**From:** Anita Gardner <Anita.Gardner@arun.gov.uk>  
**Sent:** 07 January 2021 14:28  
**To:** Planning.Responses <Planning.Responses@arun.gov.uk>  
**Subject:** FW: M/75/20/PL - 13 Elm Drive

I have checked to see whether the forward shifting of the proposed dwelling will require re-advertising and I can advise that it won't. As discussed I await receipt of the preliminary FRA and the revised plans. Can you also advise of the gross internal floor area of the dwelling?

**Subject:** M/75/20/PL - 13 Elm Drive

Site Plan 1:100

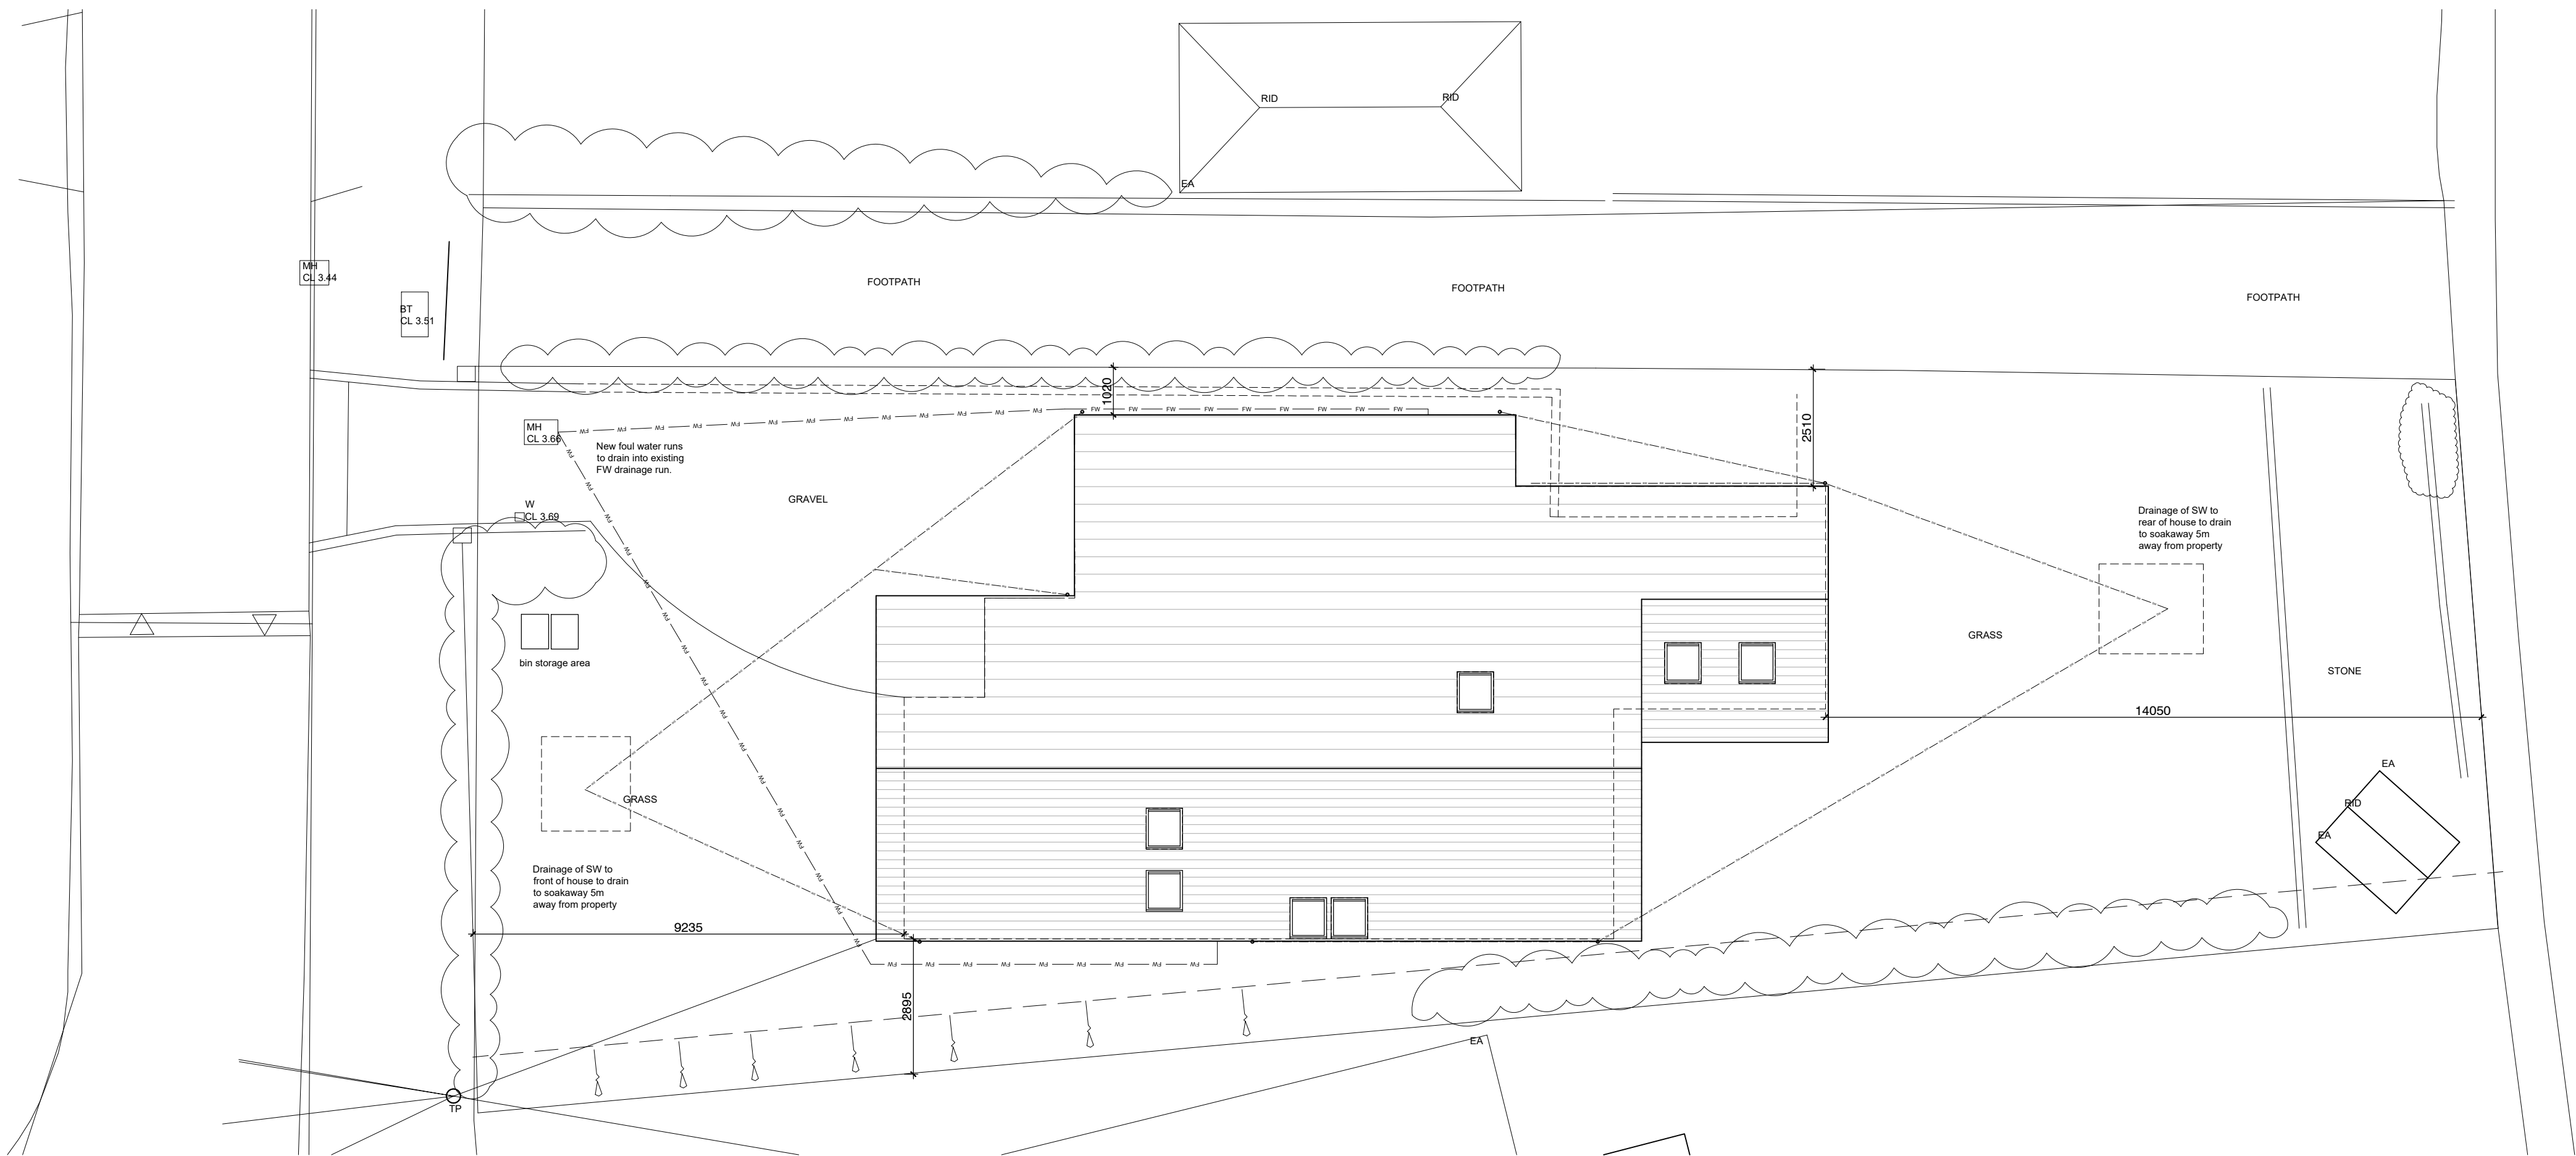
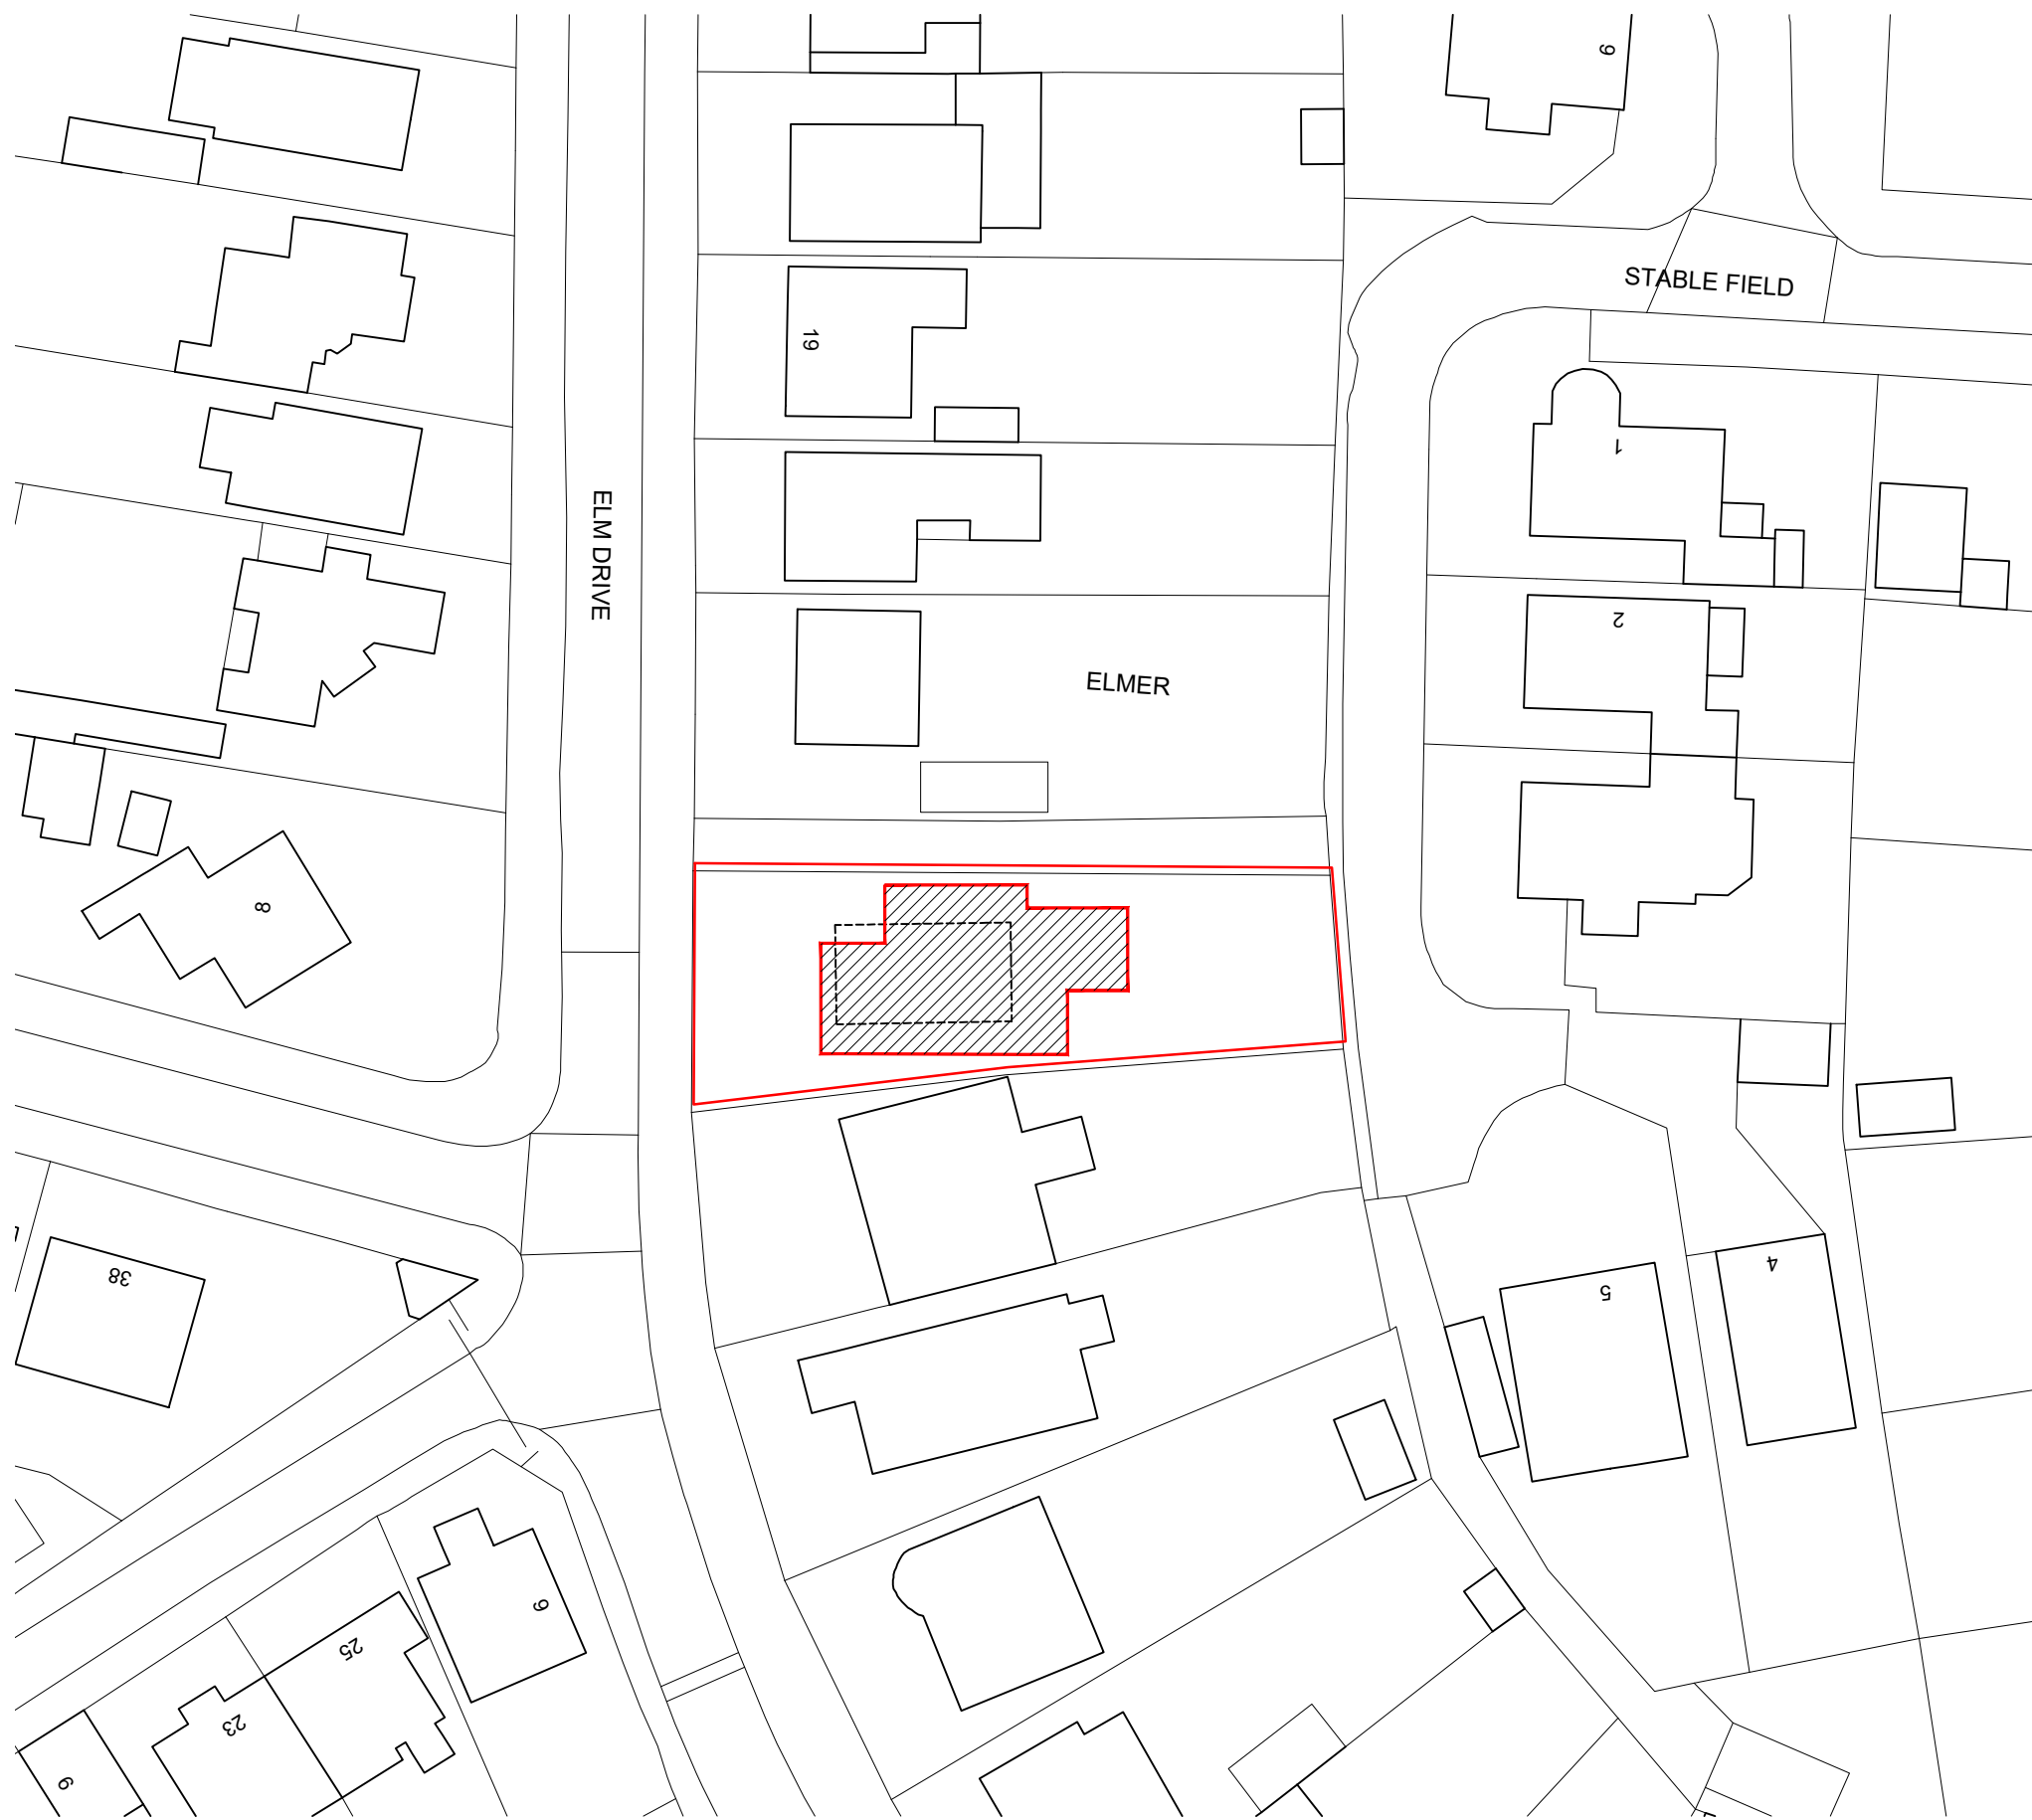
I have had the opportunity to look at your submitted application whilst awaiting the submission of the FRA and I am concerned about the height of the proposed dwelling in relation to the southern boundary. The proposal represents a significant increase in height and site coverage which is not an issue in principle, but it results in an adverse impact in the south eastern 2 storey corner of the proposal. This is too close to the adjacent dwelling no 11 and given the orientation of both dwellings would not accord with the 45 degree rule and would be overbearing to the dwelling and garden area and adversely impact the outlook from the neighbouring property.

If the FRA is on track for submission tomorrow I would suggest that you consider amending the proposal by reducing the development in the south east corner to provide a better relationship with the adjoining dwelling so that these changes can be provided whilst the Environment Agency are consulted. If the FRA is not likely to be ready by the end of this week I would suggest that the application is withdrawn and re-submitted in the new year with amended plans reducing the footprint and an FRA.

Further to your email we have look at the position of the proposed dwelling in relation to no.11 Elm drive. Please find attached a revised site plan which shows the proposed dwelling brought forward in order to sit outside the 45 degree line shown on the drawing. Please can you let me know if this would be acceptable? Please note the revised position still sits withing the existing building line along the street.
